Flood Assessment

Narwee Parklands Care Community

Prepared for Opal HealthCare c/o CYRE Projects / 03 July 2023

Response to SSDA Submission Comments

Title  
**DETAIL PLAN**  
**BASEMENT**

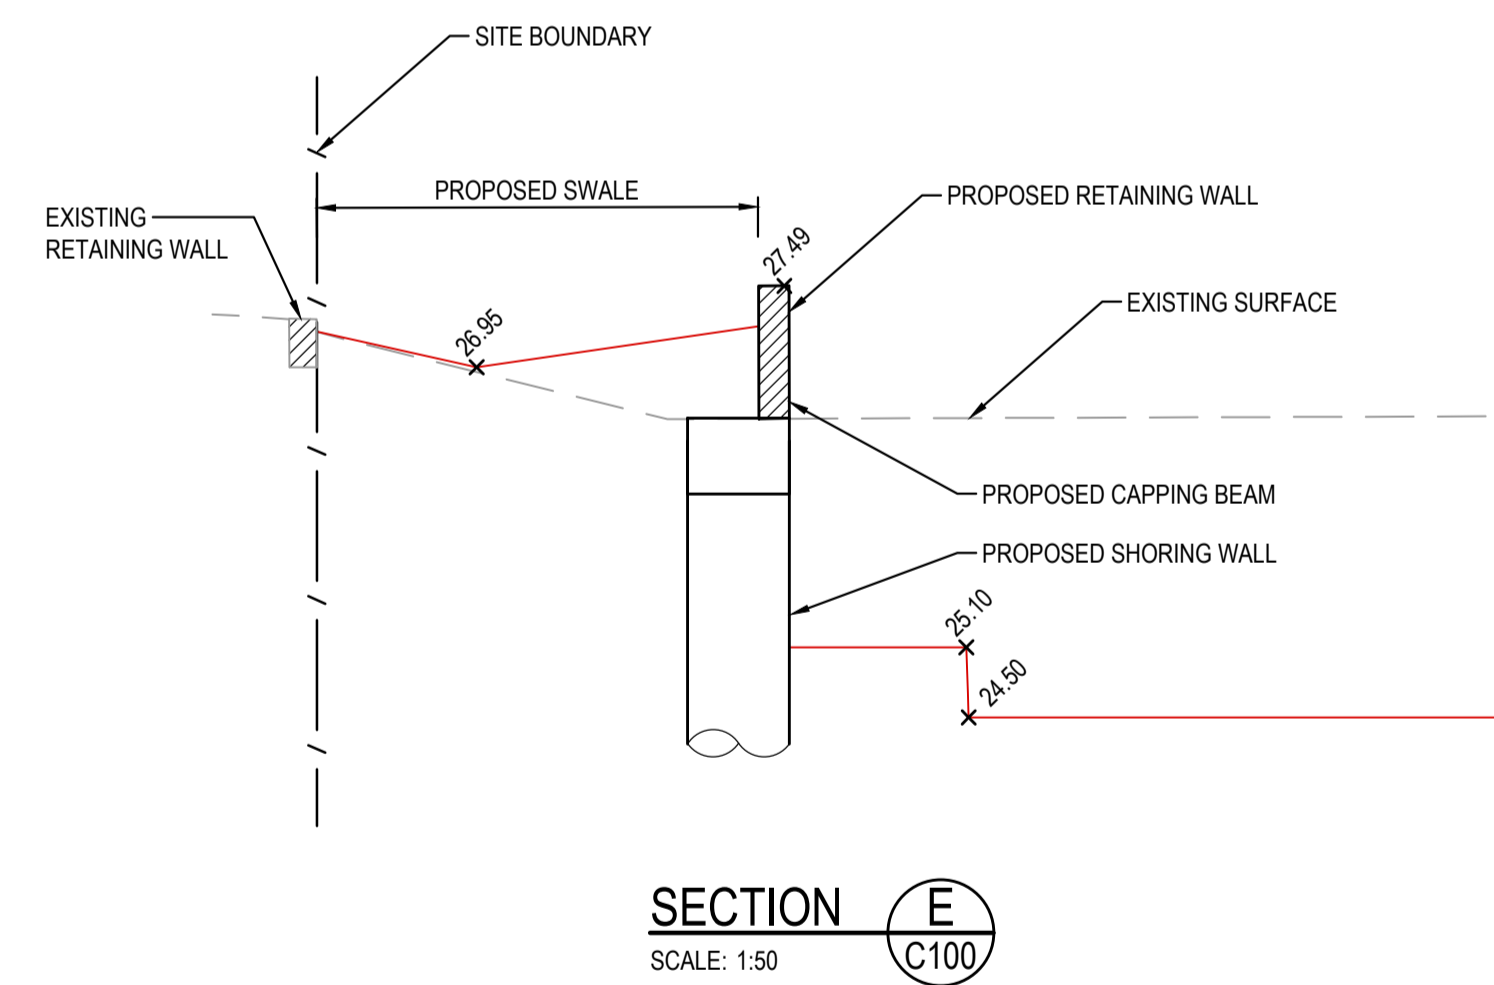
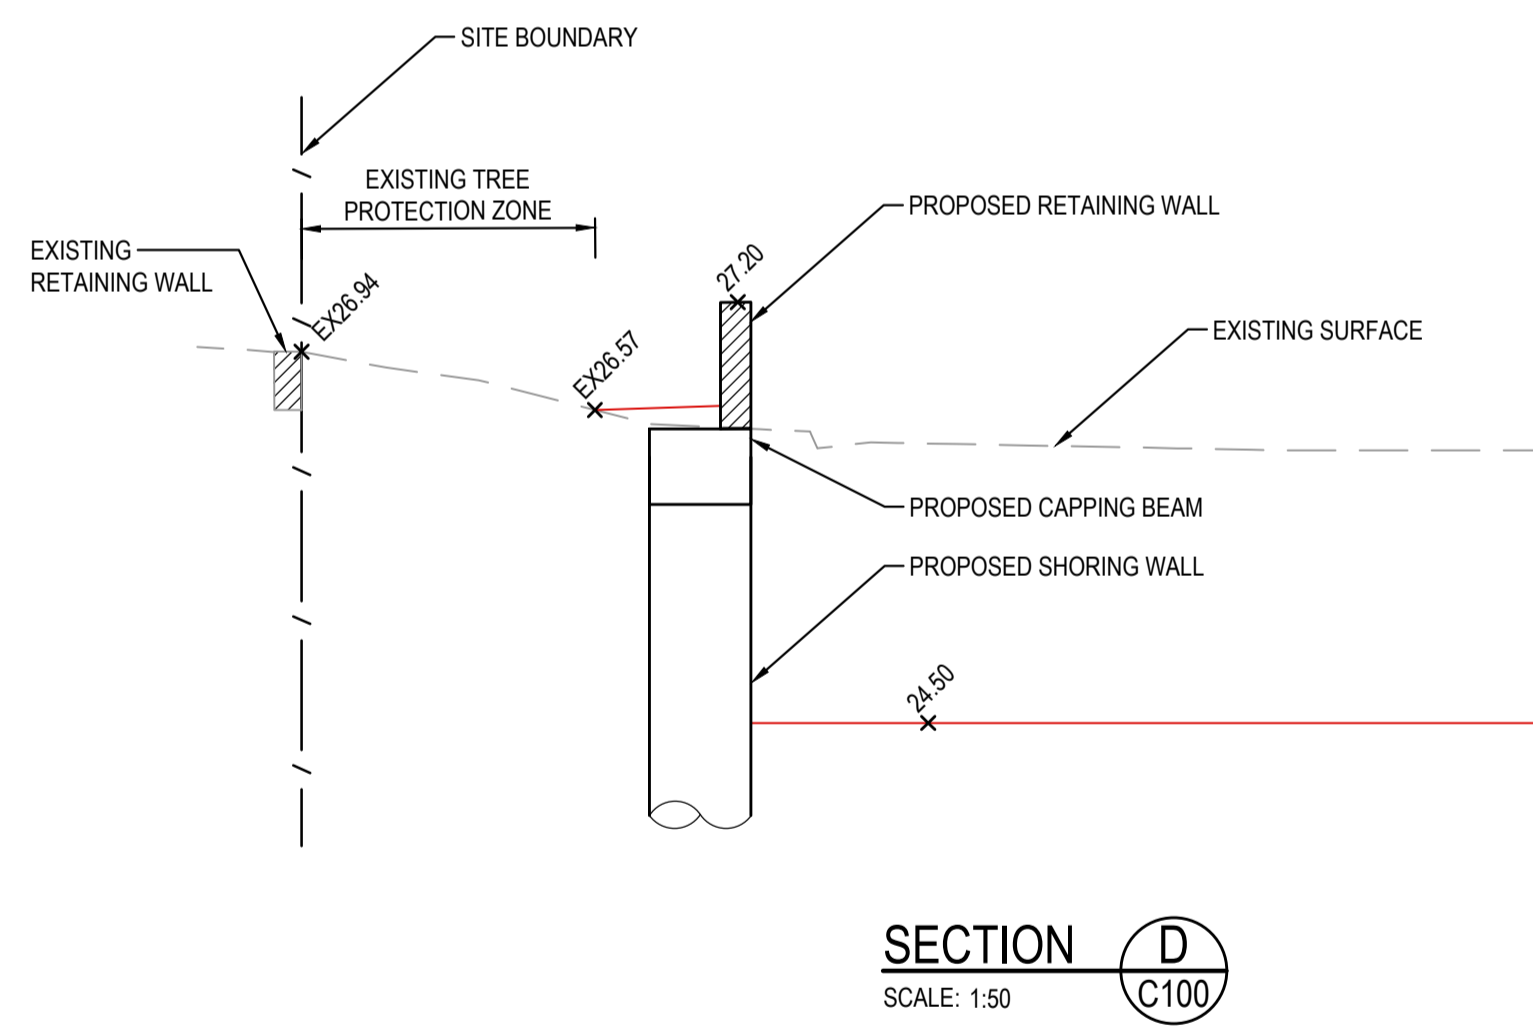
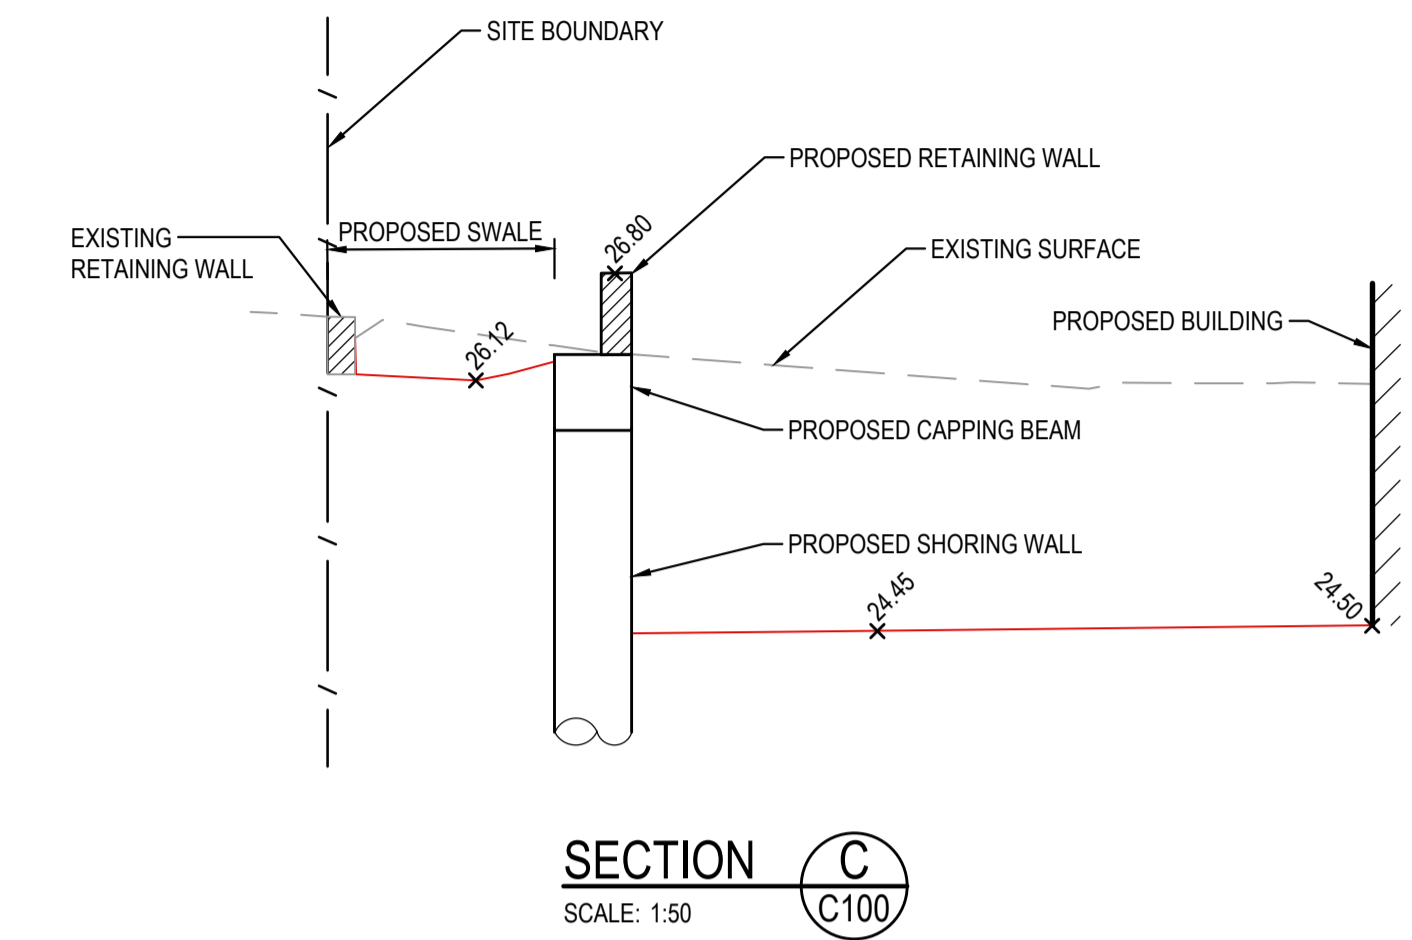
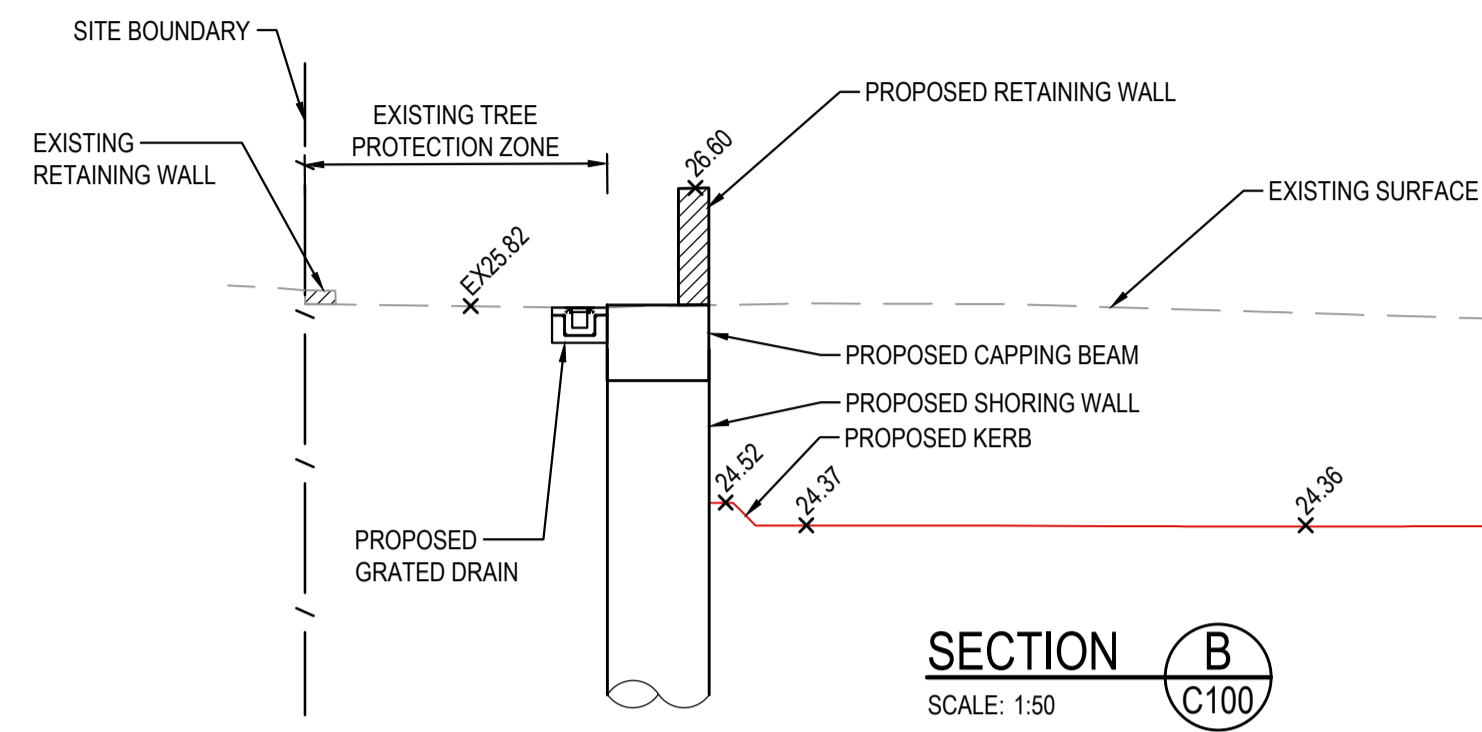
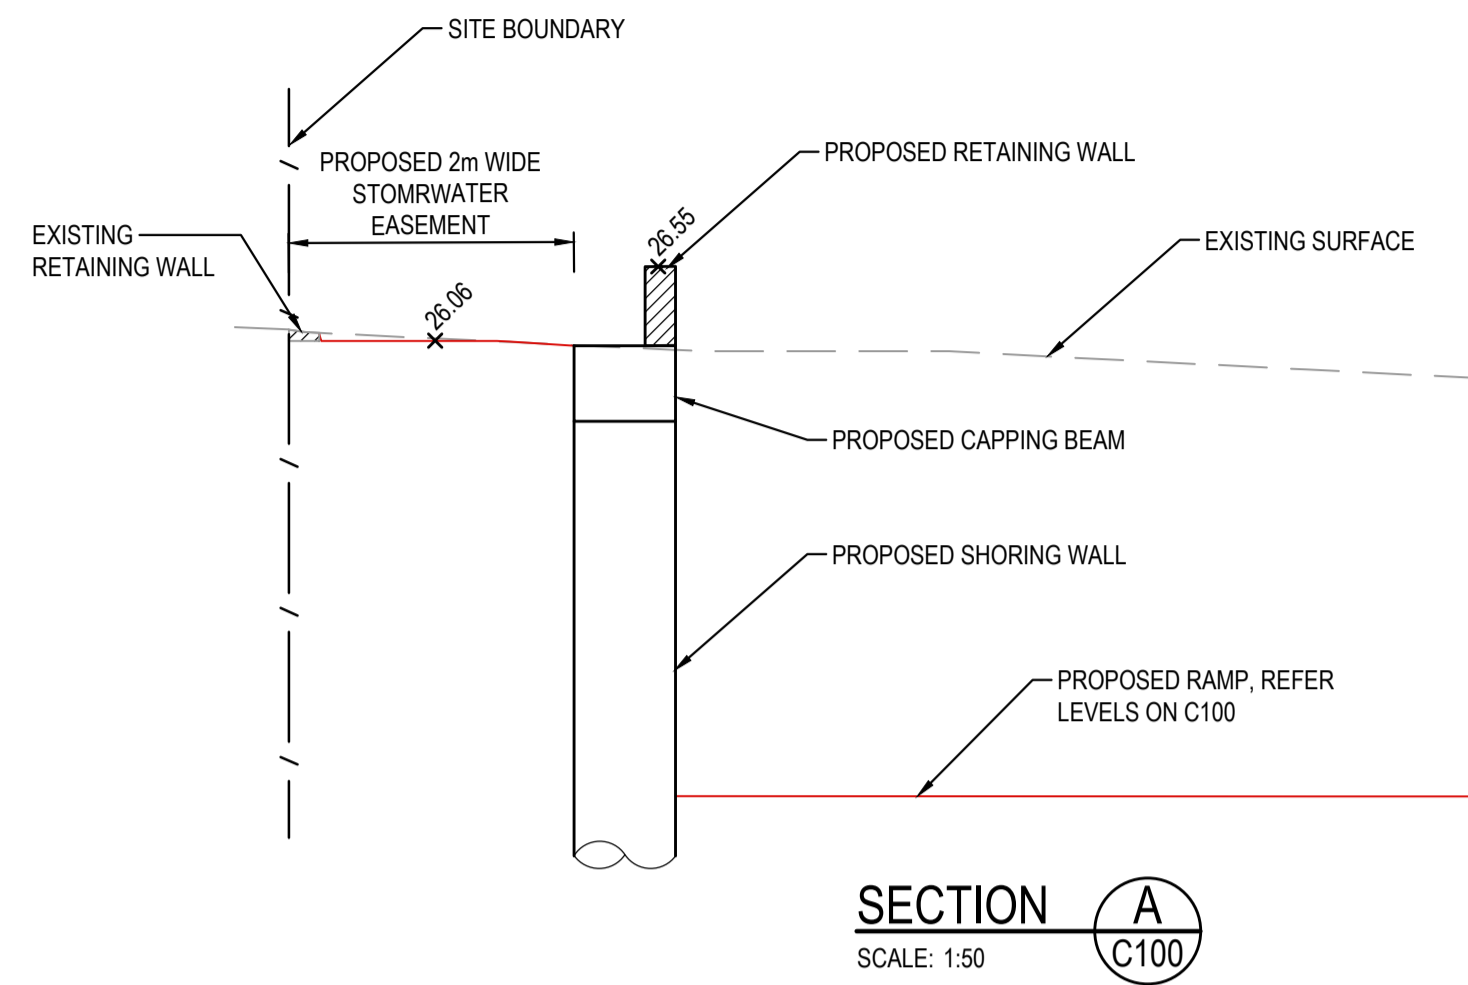
DPE	DOC23/109607	The entry level of basement parking should be above the PMF level to mitigate the potential risk of flooding under the PMF Event.	<ul style="list-style-type: none"> ▪ Egress to the basement car park has average crest level of 25.75m AHD which is equivalent to the adjacent average PMF level of 25.75m AHD. Therefore, the proposed basement car park would not be inundated with floodwaters in any storm events up to and including the PMF. Refer Section 6.0 for details.

Agency / Organisation	Agency Reference	Comment from Agency / Organisation	Section Reference / Response
DPE	DOC23/109607	<p>The proponent should ensure the performance of retaining walls (such as reliability, stability and durability) under the PMF Event in order to eliminate any flood affectation at the basement of the building. Furthermore, a site emergency management plan should be developed by engaging a qualified professional to ensure the continuity of operations given the criticality and sensitivity of the proposed facility and its receptors under major flooding events including the PMF Event.</p>	<ul style="list-style-type: none"> ▪ The civil package considers draining flood waters such that it does not inundate the site. ▪ the proposed civil design package prepared by Henry & Hymas for the site effectively renders the site flood free during both 1% AEP and PMF events. Overland flows arriving from the northern site boundary are effectively redirected to Karne Avenue through the proposed retaining wall and drainage system at the northern boundary. ▪ The proposed retaining wall structure will be designed to withstand the forces of floodwater, debris and buoyancy up to and including the PMF (details to be provided by structural engineers at the detailed design stage). ▪ A Flood Risk Management Plan (FRMP) has been prepared for the site to provide recommendations to ensure that in the event of a flood, risk to personal safety is appropriately managed (Refer Section 8.0). ▪ The Flood Emergency Response Plan (FERP) also provides appropriate flood response strategies for the future site users (refer Section 8.3).
